13 January 2020

RESPONSE TO REQUEST FOR ADDITIONAL INFORMATION – ALTERATIONS AND ADDITIONS TO MERIDEN SCHOOL (SSD-9692)

This letter has been prepared by Urbis on behalf of Meriden School (the Applicant) in regard to the Alterations and Additions to Meriden school (SSD-9692).

PROPOSED ILLUSTRATIVE PLAN

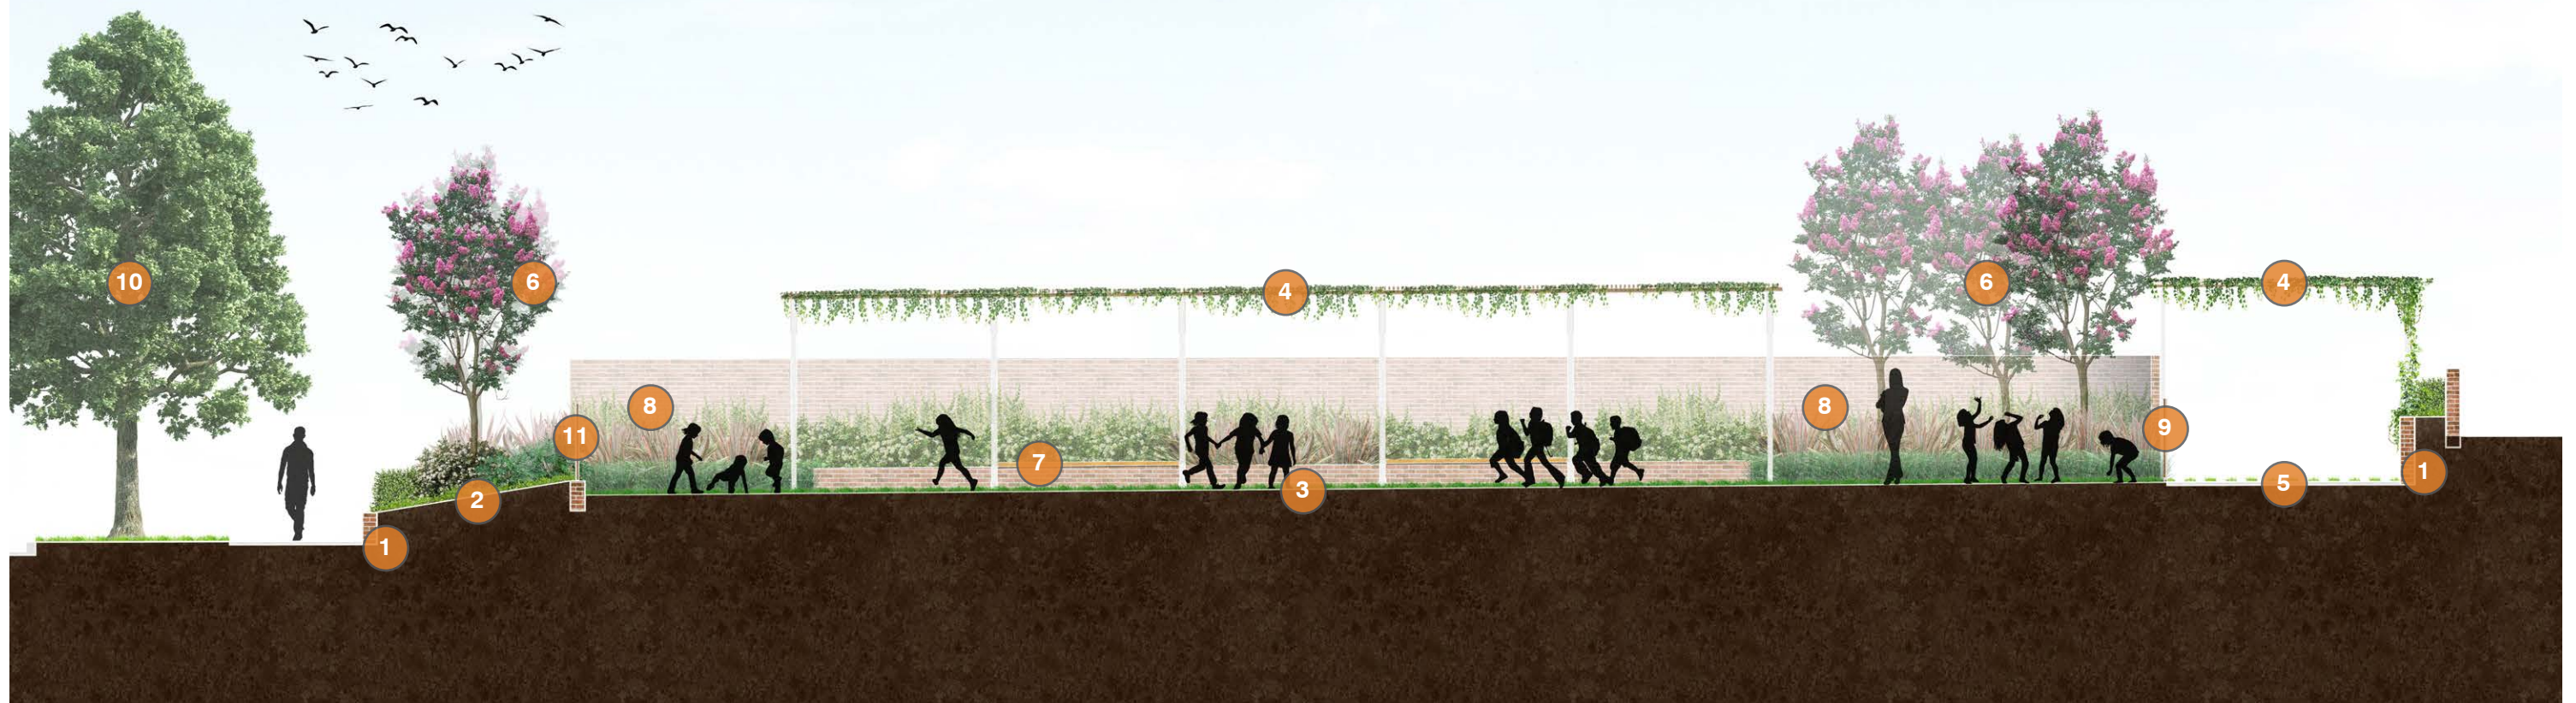
1. Confirmation of the existence of the 'existing' fence referenced in the RtS and the location of the site boundary.

2. If making good works to the 'existing' timber fence is no longer proposed, confirmation that the predicted noise levels from the use of the proposed adjoining playground do not rely on the upgraded 1.8 metre high fence in order to comply with the 43 dBA project noise trigger level.

It is proposed to improve this rear fence (e.g. re-nailing fence palings, replacement of some palings etc.) to ensure amenity can be further enhanced. The location of the fence to be made good has been corrected in the Landscape Plan (refer to Figure 2).

Response: There is not an existing fence located between 2 Vernon Street and the proposed playground. A shared driveway is located between the two properties. The reference to a fence in this location has been removed from the Landscape Plan and the Acoustic Report to avoid confusion.

The location of the site boundary has been outlined on the updated Landscape Plan.
